EPC DPW Stormwater-PCM Applicability Form Comments.pdf Markup Summary

3ILITY FORM	Subject: SW - Textbox	PPR2619
PPR2619	Page Label: 1	
	Author: Mikayla Hartford	
	Date: 7/29/2026 2:25:13 PM	
	Status:	DMC RESPONSE: Number added
	Color: 	
	Layer:	
	Space:

Water Quality Treatment Summary Table		
Basin ID(s)	PCM Tributary Area	PCM ID
Y1-Y3	1.76	EDB-1
P1-P4	3.00	Runoff Reduction
EXCL-1	0.80	EXCLUDED
EXCL-2	0.52	EXCLUDED

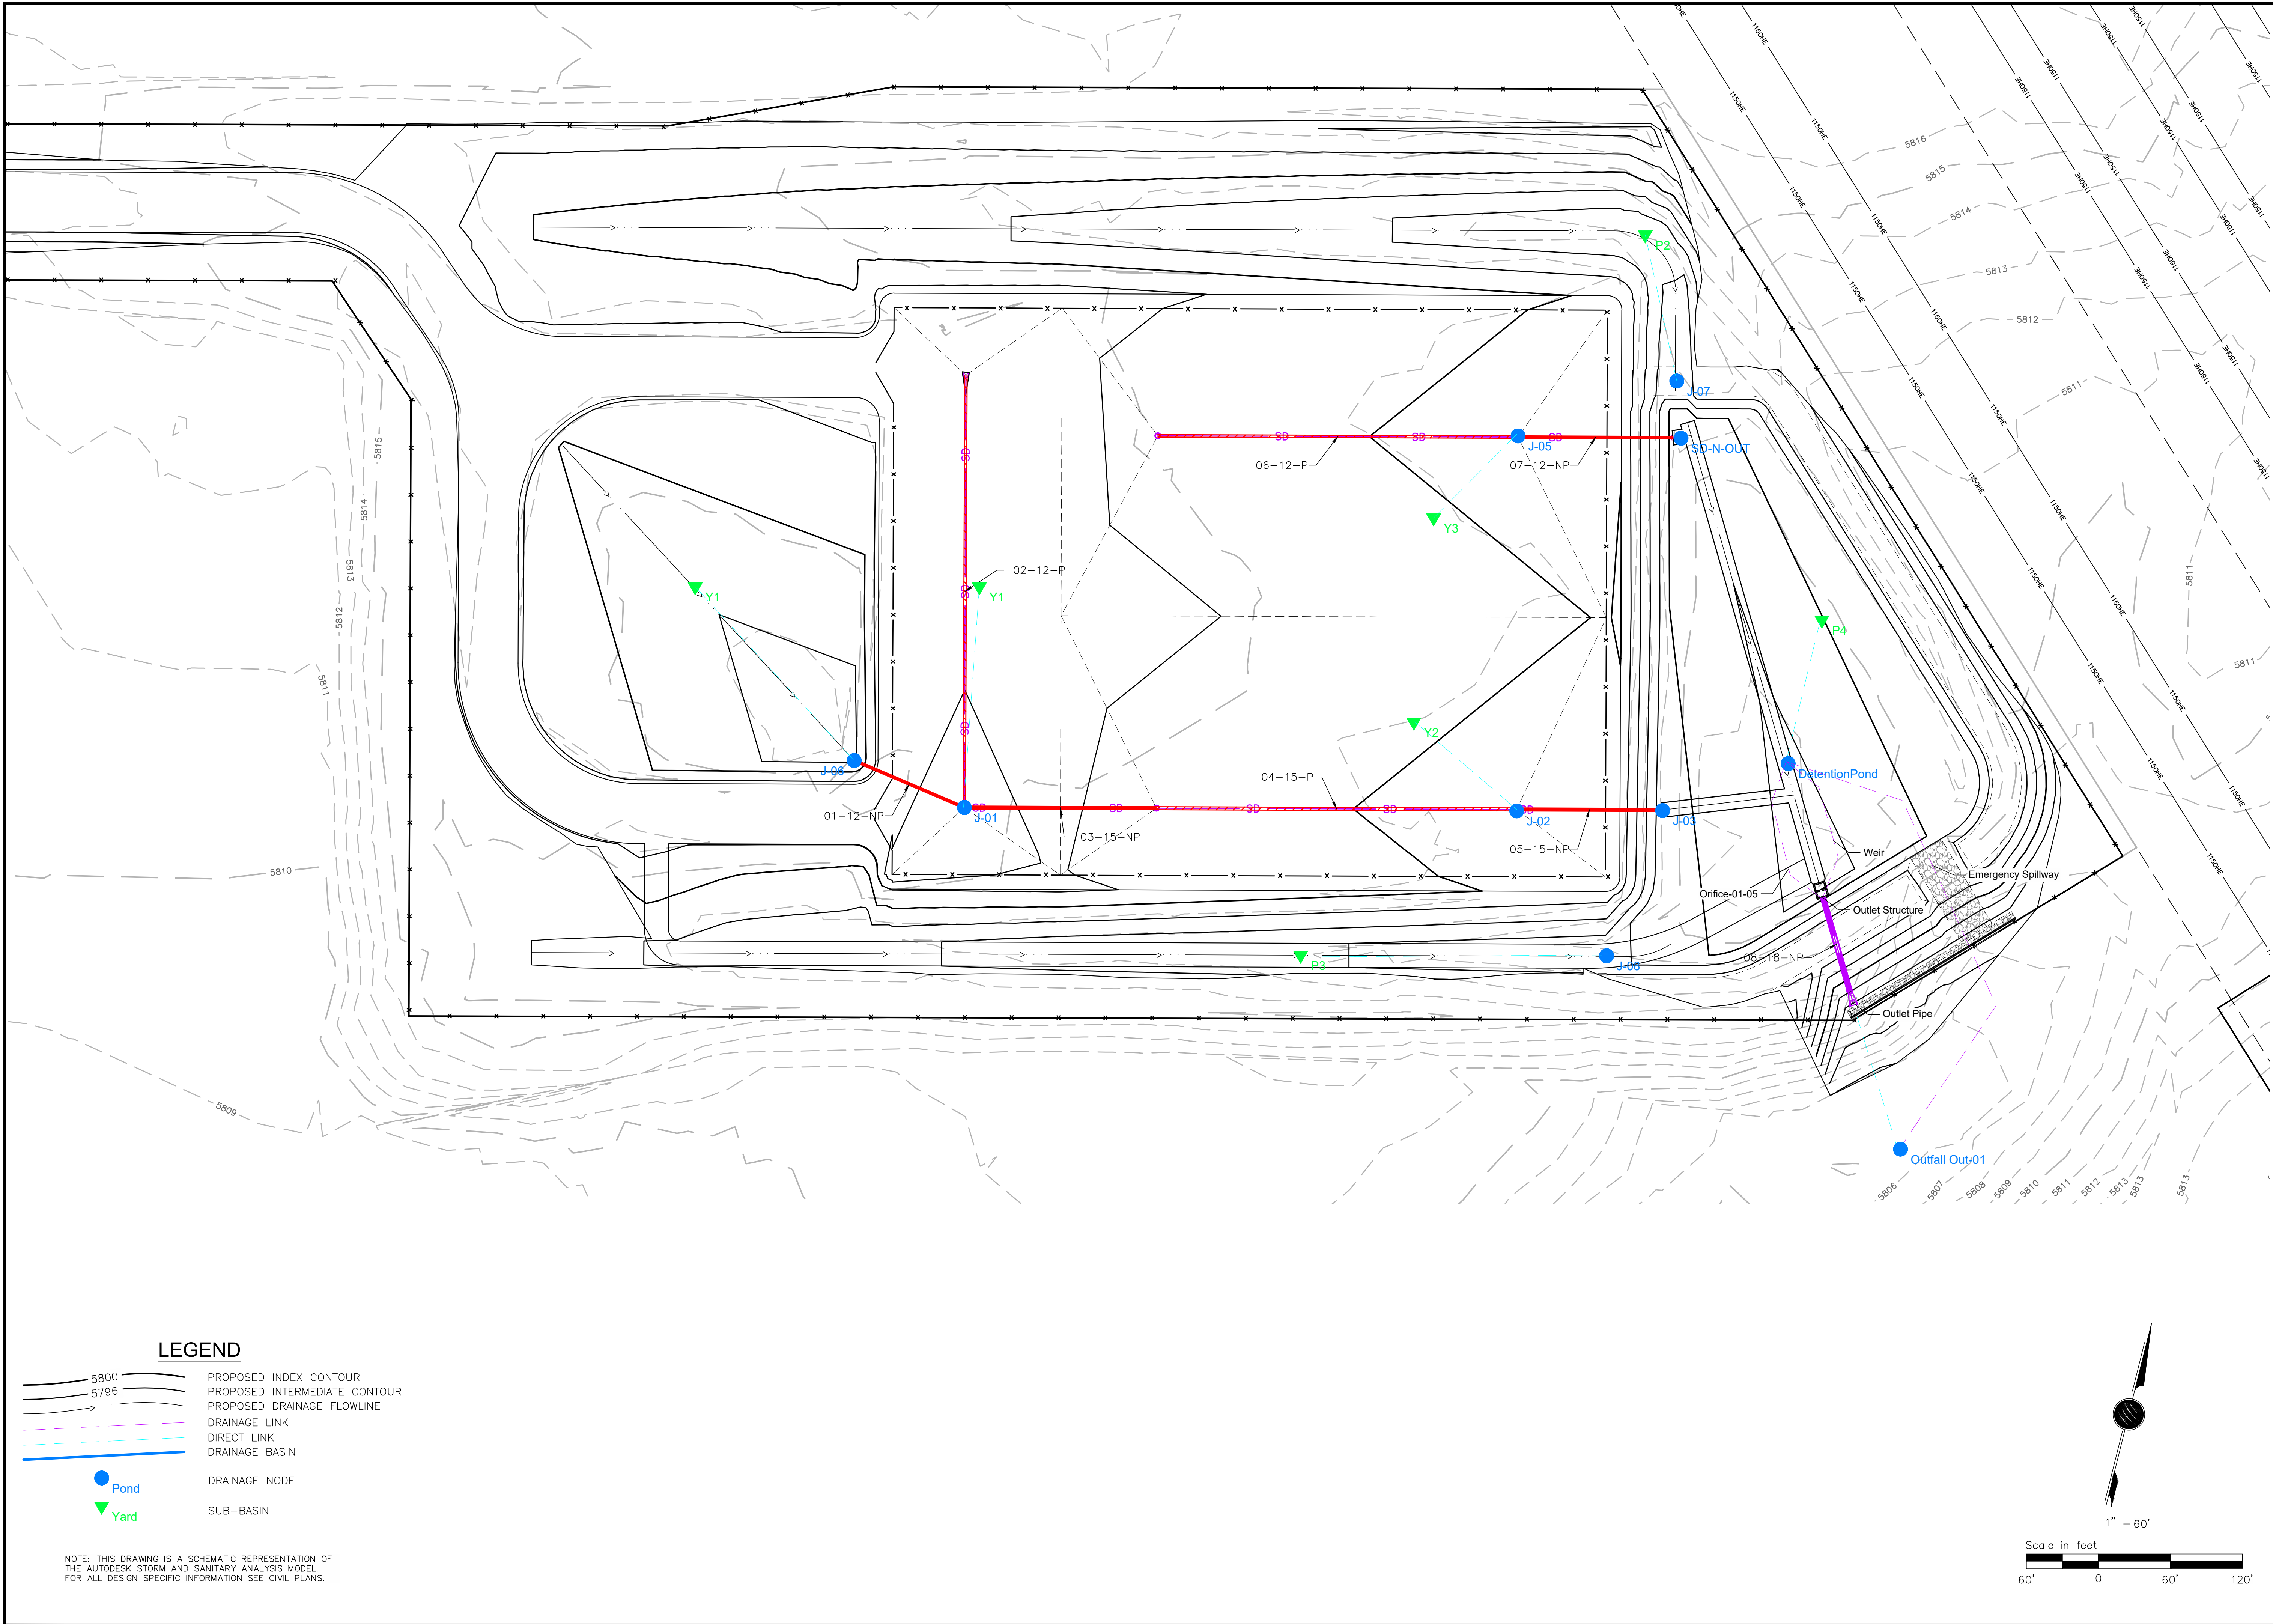
0.52 ac	Subject: SW - Textbox	0.52 ac
	Page Label: 2	
	Author: Mikayla Hartford	
	Date: 7/29/2026 2:25:50 PM	
	Status:	DMC RESPONSE: Acreage added (updated value is now 0.46 acres)
	Color: 	
	Layer:	
	Space:

Subject: SW - Textbox with Arrow	per the notes below
	Page Label: 2	
	Author: Mikayla Hartford	
	Date: 7/29/2026 2:26:03 PM	
	Status:	DMC RESPONSE: Acreage added (updated value is now 0.46 acres)
	Color: 	
	Layer:	
	Space:
